EP-24-0010 Owl Marketplace Filing 1
NE¼ SE¼ Section 1, T13S, R65W, 6th Meridian
39.9459, -104.6082
File Number: VR2321
Final plat to create one residential lot into five (5) commercial lots.

With this referral, we received a request to provide Review Comments (Email dated January 8, 2024); Construction Drawings (Drexel, Barrell & CO., January 3, 2024); Final Drainage Report (Drexel, Barrell & CO., January 2024); Final Plat (Drexel, Barrell & CO., May 30 and October 20, 2023); and other documents. The Soils and Geology Study (Entech Engineering, Inc., June 22, 2023) was previously reviewed; no update to this report was provided.

JOB NO.
230745
FIG. 6

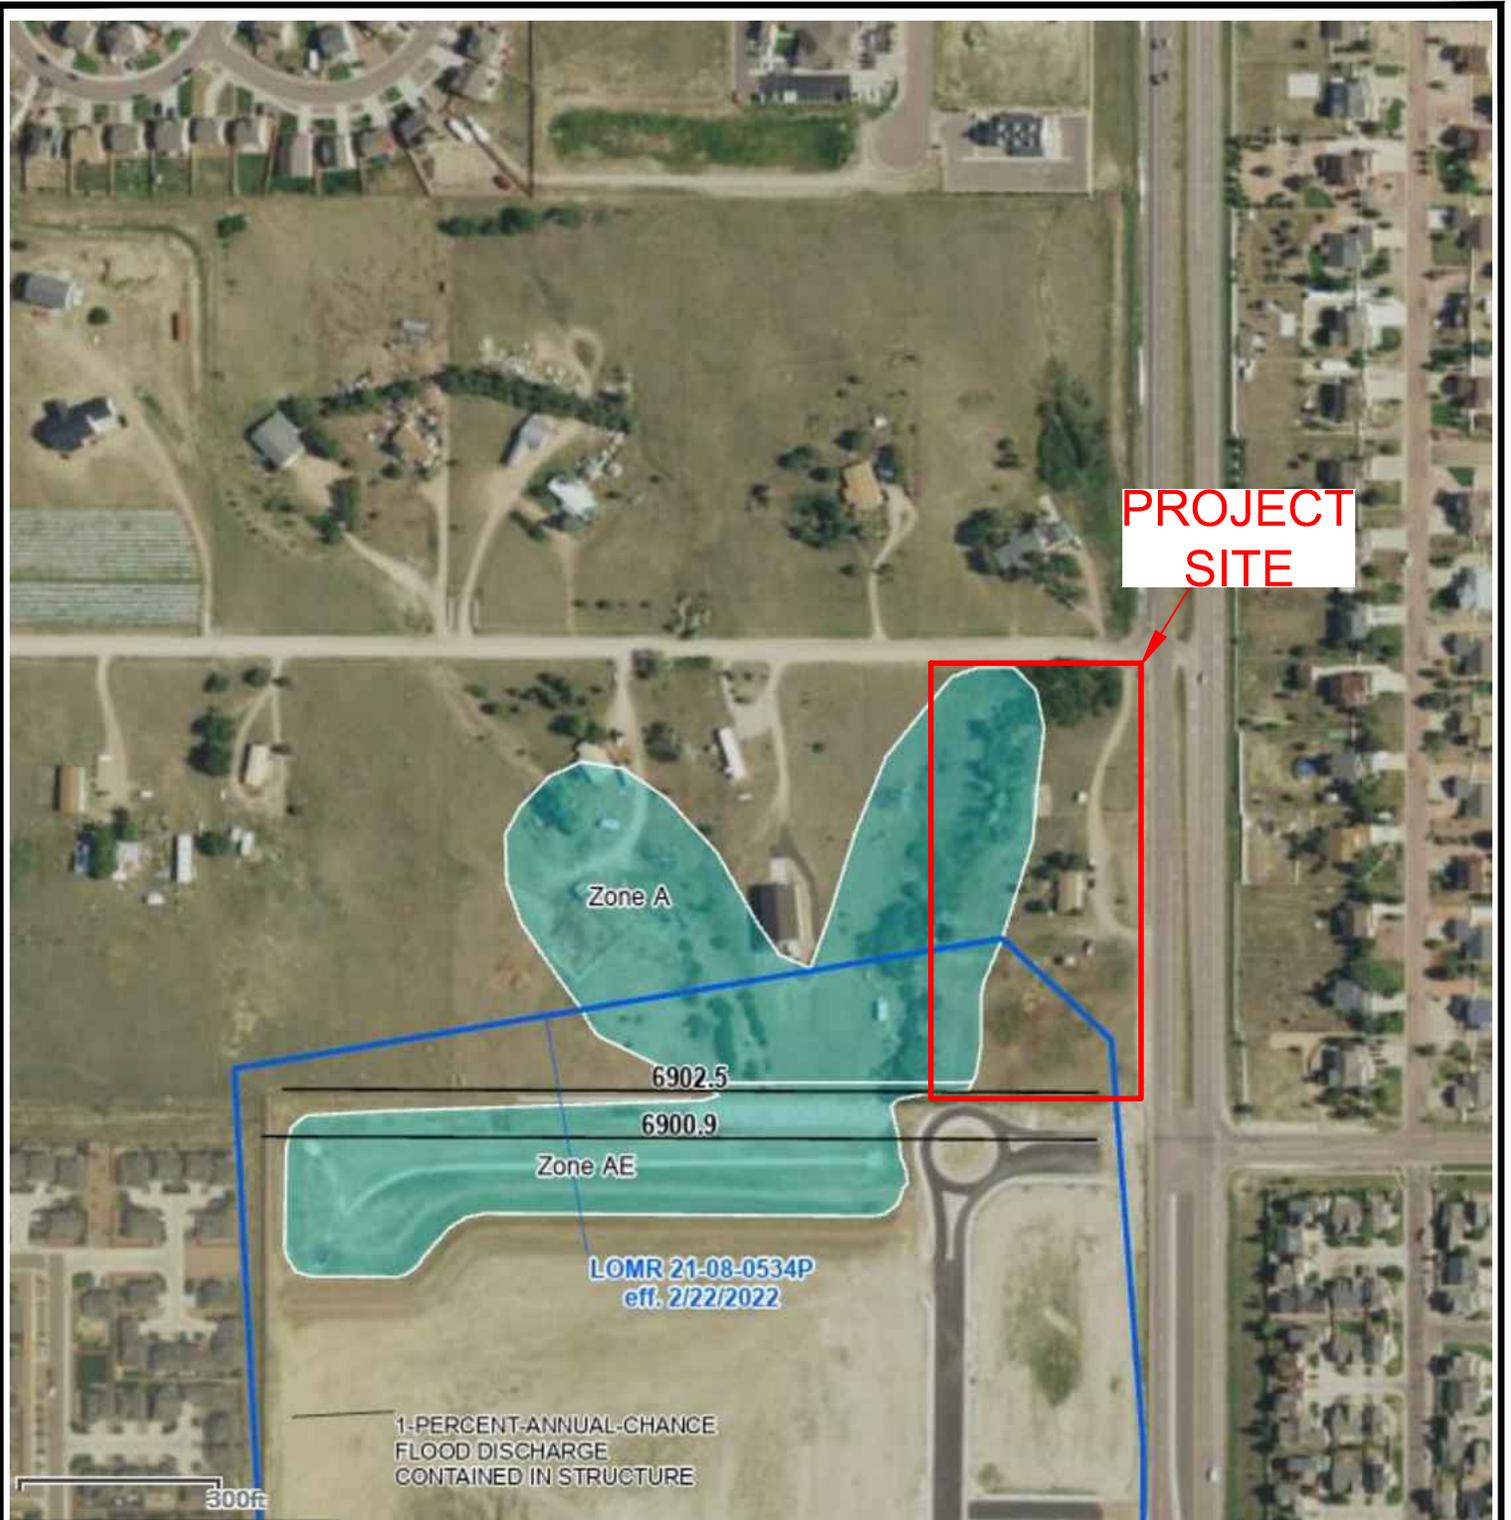
1. Entech's Figure 6 shows geologic hazards and constraints within certain areas of the property. However, only Tbs (Black Squirrel Formation) is shown in the eastern portion of the lots. Based on our review of Entech's boring logs, seasonal shallow water and expansive soils should also be included in this area. The legend should be updated to include missing symbols (sw, fp, and w) and the correct description of Tbs (Black Squirrel, not Pierre Shale). Additionally, a geologic hazard note has been added to the final plat, however, a generic response without reference to Entech's geology study was provided. CGS recommends that Figure 6 be updated and a note added to the final plat listing the geologic hazards and constraints, along with mitigation measures.
